Dean Moor Solar Farm

Applicant Responses to ExA's Written Questions 1 (1 of 2 docs)

26 August 2025
Prepared by: Stantec UK Ltd
PINS Ref: EN010155
Document Ref: D2.7
Deadline 2
Revision: 1

Drawing file: published-documents / EN010155-000074-6.2 ES Figure 6.1 Designated Heritage Receptors within 3km of the Order Limits.pdf

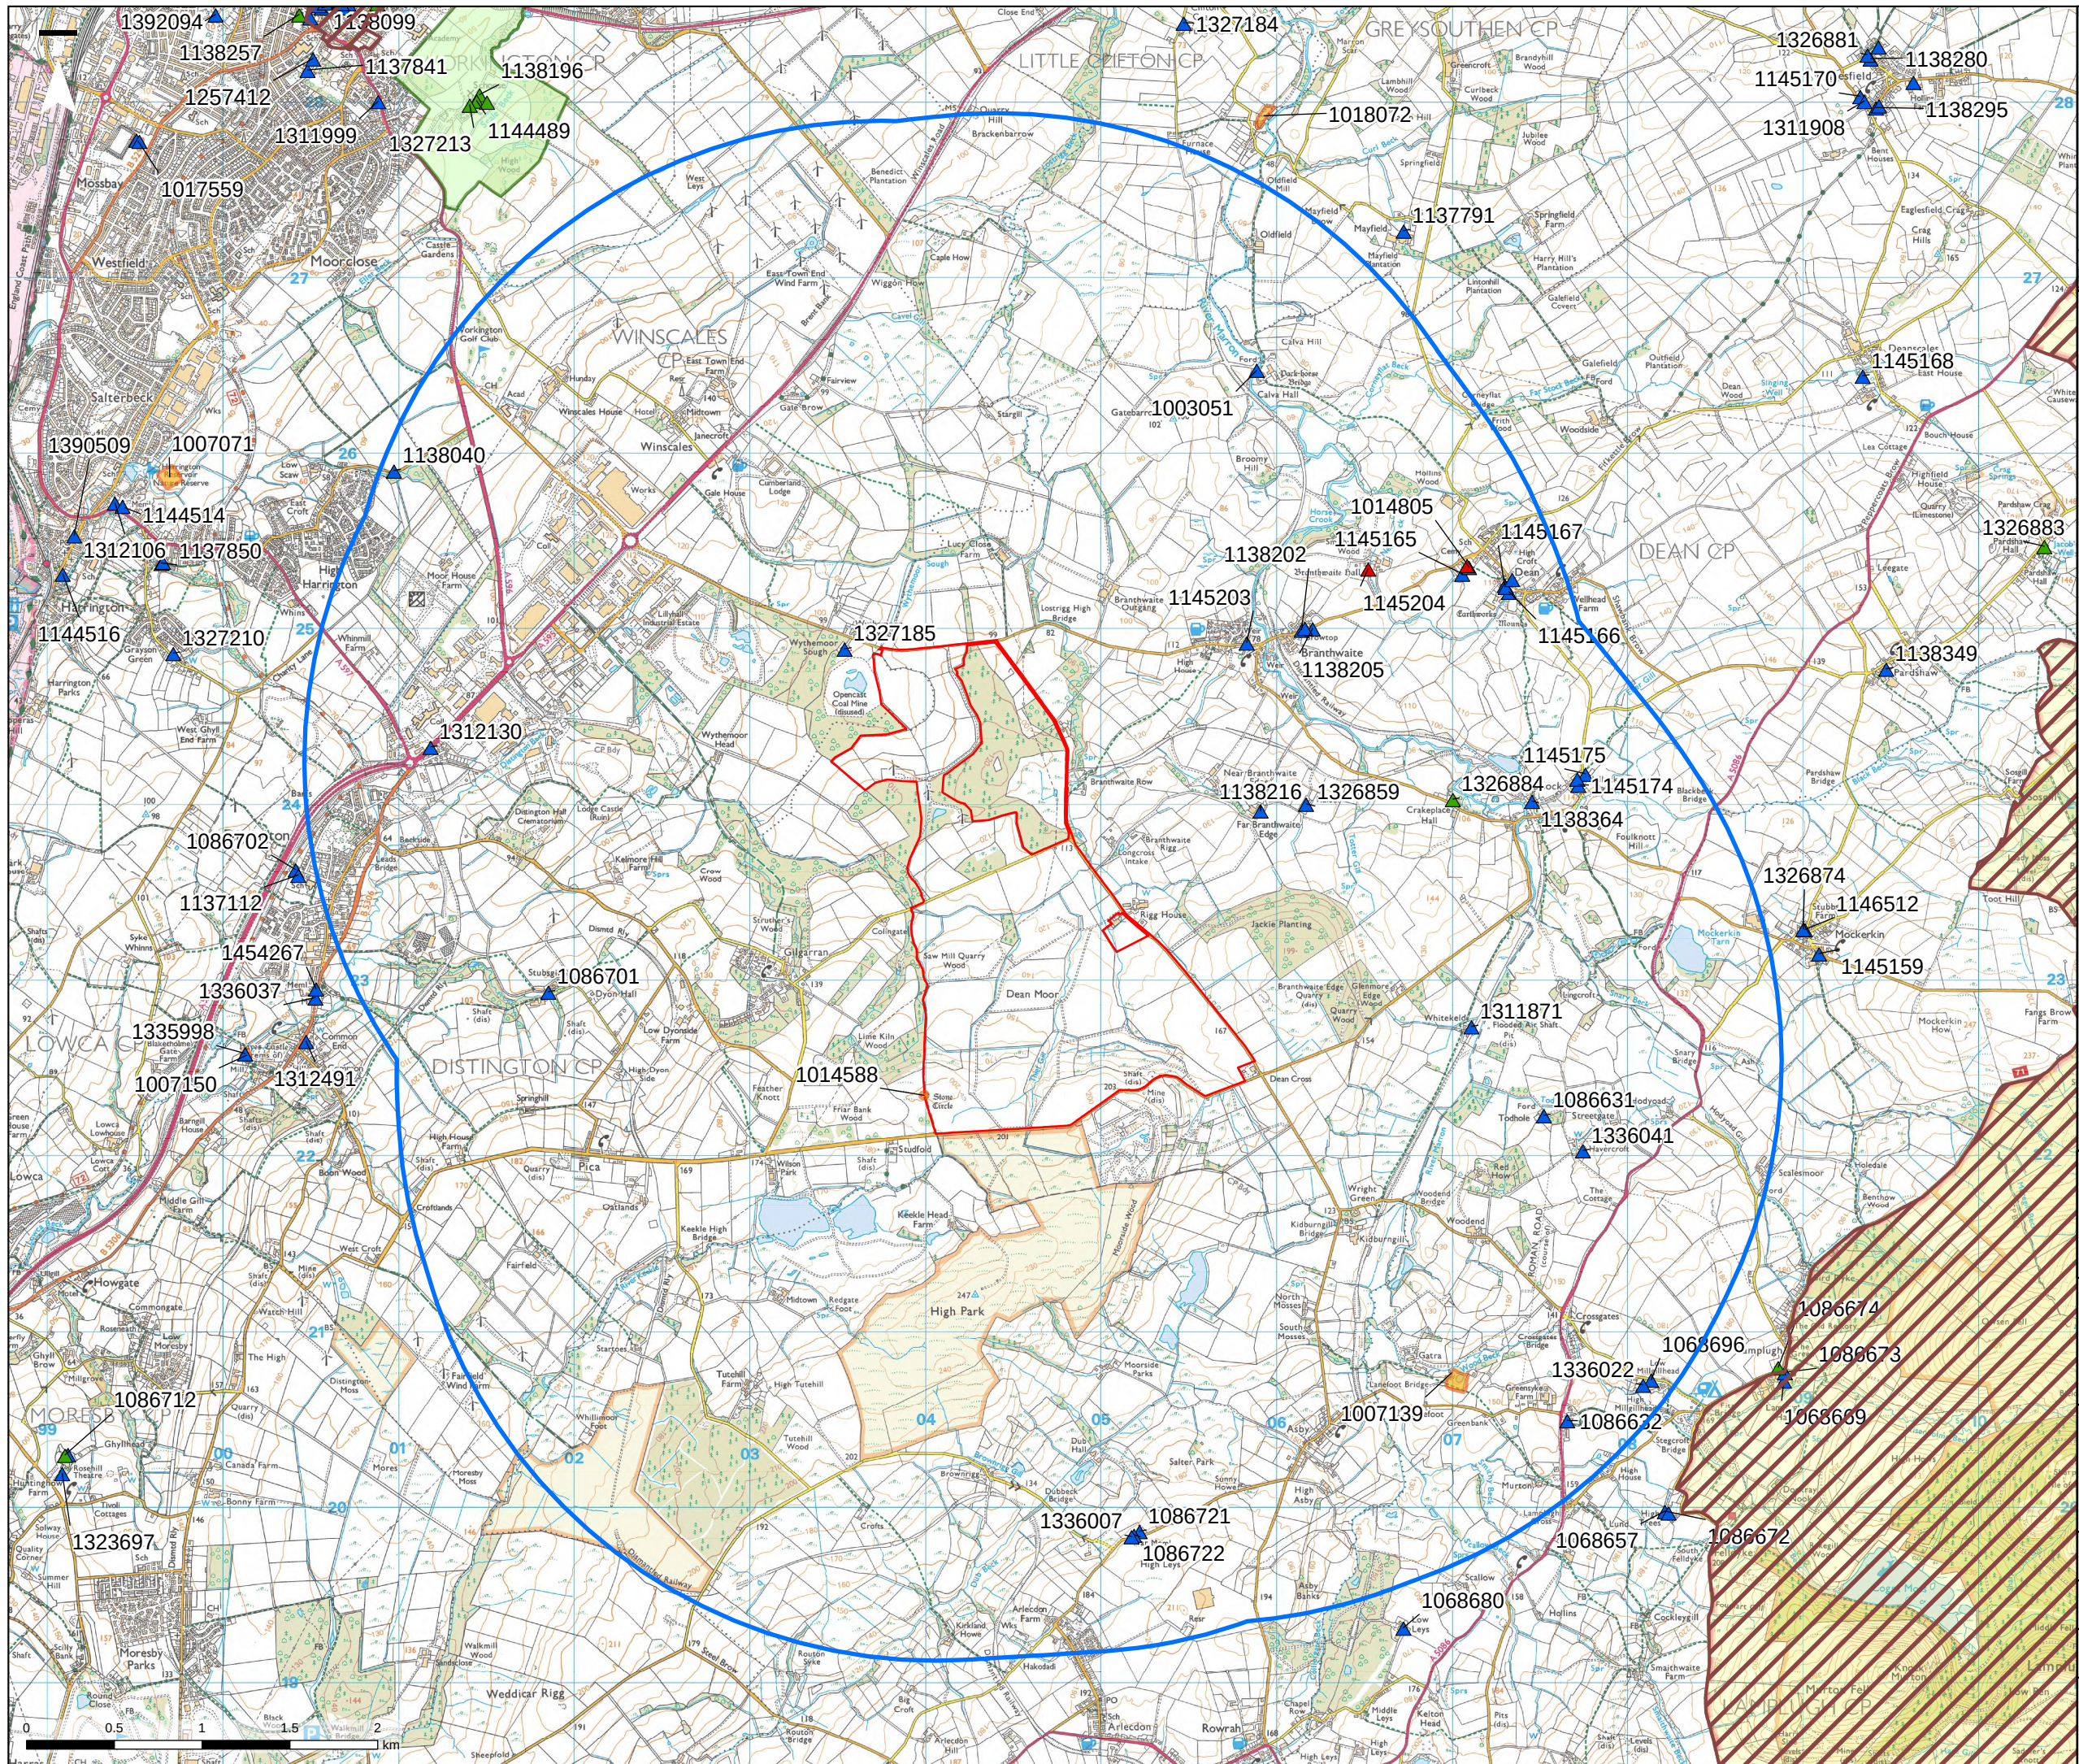
Q5.0.10	<p>Question: <i>The figure showing Heritage Assets within 3km [APP-076] illustrates that the boundary of Conservation Areas is identical to the boundary of the WHS. Please amend the plan if it is incorrect.</i></p> <p>Response:</p> <p>This is an error in the legend including on Figure 6.1 within ES Chapter 6 [APP-037].</p> <p>The Applicant can confirm that the WHS designation does not benefit from an additional designation as a Conservation Area. An updated version of ES Figure 6,1, 'Heritage Assets within 3km' [APP-076] is provided with the Deadline 2 submissions.</p>

## Environmental Statement: Chapter 6 – Figure 6.5 Stone Circle with Landscape Strategy Plan on behalf of FVS Dean Moor Limited

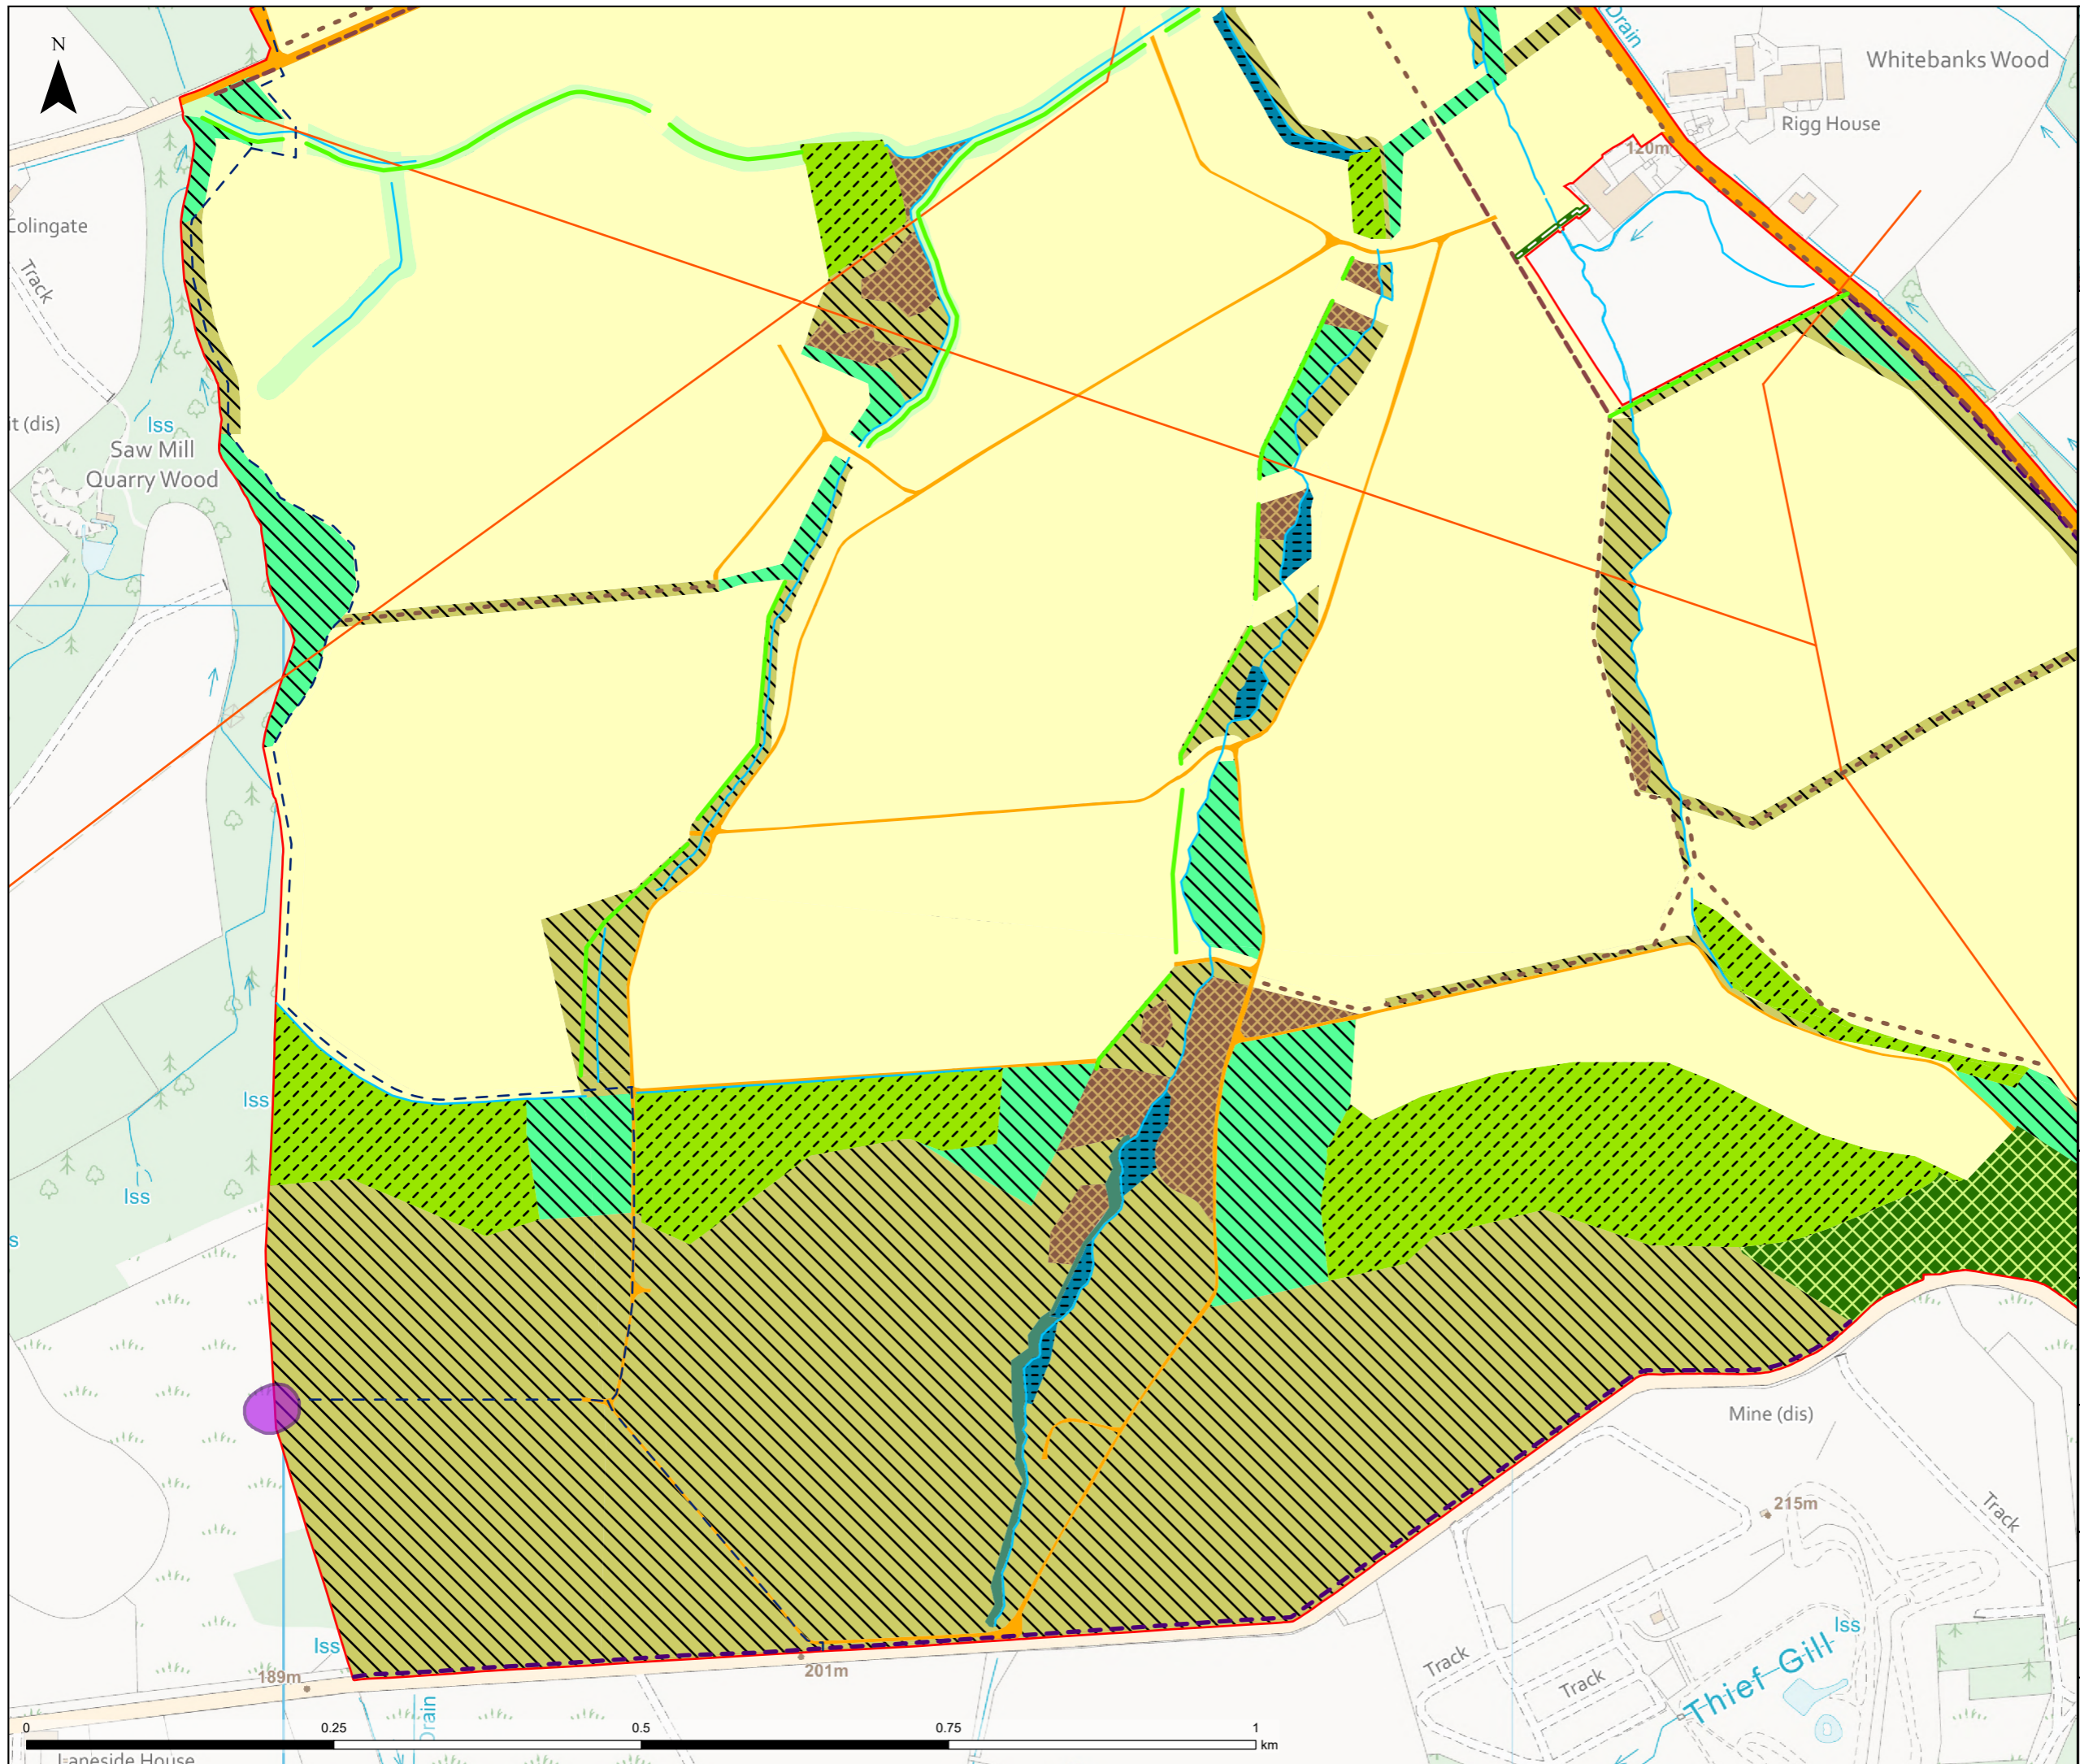
No.	Question / Applicant's Response
	<p>5) <i>The extent of harm both without mitigation and the residual harm. This should be framed in relation to NPS EN-1, identifying the broad level of harm in these terms (substantial/less than substantial) and calibrating by setting out the harm within the broad level (for example, low, moderate, high level of less than substantial harm).</i></p> <p>6) <i>The specific public benefits in relation to each asset, where harm is identified.</i></p> <p><i>The ExA recognise that many aspects of this assessment have already been documented in chapter 6 of the ES. However, the ExA note that limited detail has been included in terms of potential enhancement (for example, [APP-027] recognises that appreciation of the designated Stone Circle will be enhanced through cultural heritage management strategies, but it is not clear what this management strategy is and how enhancement would be sought). It would assist the ExA if good practice guidance, such as that issued by Historic England (the Setting of Heritage Assets, 2017), was referred to in this respect. The above will ensure identified heritage impacts can be more readily interpreted by the ExA in the context of national legislation, policies and objectives.</i></p> <p>Response:</p> <p>In response to the list of items provided by the ExA, the following points of clarification are provided and summarised in the table which can be found at Appendix G [D2.7].</p> <ol style="list-style-type: none"> 1. The HEDBA [APP-112] identifies which heritage assets, and their settings would be affected by the Proposed Development. A Gazetteer of all heritage assets identified within the study area is provided at Appendix 1 of the HEDBA. 2. Where heritage assets within the study area have been identified as having potential to be impacted by the Proposed Development, they have been scoped into the assessment undertaken in the HEDBA. A detailed significance assessment is provided for each of these assets at 4.2 of the HEDBA. This includes consideration of the degree to which the setting of each asset makes to its heritage significance, if any. 3. Where heritage assets have been identified as having potential to experience an impact arising from the Proposed Development, the HEDBA provides an assessment of the anticipated impacts at Table 5.1. Where significant effects are identified and taken forward into ES Chapter 6, a detailed assessment of the effects of the Proposed Development has been undertaken. Table 6.3 within Chapter 6 clearly states whether the effects would be beneficial or harmful. 4. ES Chapter 6 demonstrates the embedded design mitigation to maximise enhancement and to avoid or minimise harm, including details as to the measures proposed in each case (for example the Archaeological Mitigation Strategy, ES Appendix 6.3 and the landscape buffers and green infrastructure shown on the LSP [APP-088]) 5. Table 6.8 'Table of Significance – Residual Effects' in Chapter 6 details the Significance of Effect of each receptor and the corresponding level of harm in accordance with the NPPF tests, substantial harm / less than substantial harm. Where less than substantial harm is identified, this is quantified as negligible, low, medium, high levels of less than substantial harm. 6. The specific public benefits have been detailed within the Planning Statement were applicable [AS-011].

No.	Question / Applicant's Response
	<p>ES Figure 6.5 of the ES [D2.32] shows the proposed landscaping and permissive path access for (which would better reveal the significance of the Stone Circle by enabling public access and engagement with the asset). The details of interpretive materials (e.g. information boards) in regard to the Stone Circle will be provided as part of the LEP and LEMP.</p>
Q5.0.7	<p>Question: <i>English Lake District World Heritage Site (WHS) – chapter 6 of the ES. The ExA require the following clarification/information:</i></p> <ul style="list-style-type: none"> • <i>a copy of the relevant Management Plan for the WHS</i> • <i>an understanding of the relevance of the Lake District National Park Partnership's Management Plan 2020-2026 for the purposes of the WHS and for the purposes of identifying the significance of the WHS.</i> <p>Response:</p> <p>The Applicant has provided a copy of the LDNP Partnership's Management Plan (PMP) 2020-2026 at Appendix H of this document. [D2.7].</p> <p>Along with the sources listed in the HEDBA [APP-112] (such as the UNESCO WHS nomination documents), the PMP was used to establish the significance (or value) the of WHS for the purpose of the EIA. The PMP sets out the Partnership's vision and aspirations for the WHS and seeks to "ensure that the public benefits the natural and historic (and/or cultural) environment of the Lake District provides continue to deliver for future generations." It also identifies key challenges and objectives in order to manage change within the WHS to preserve its OUV.</p>
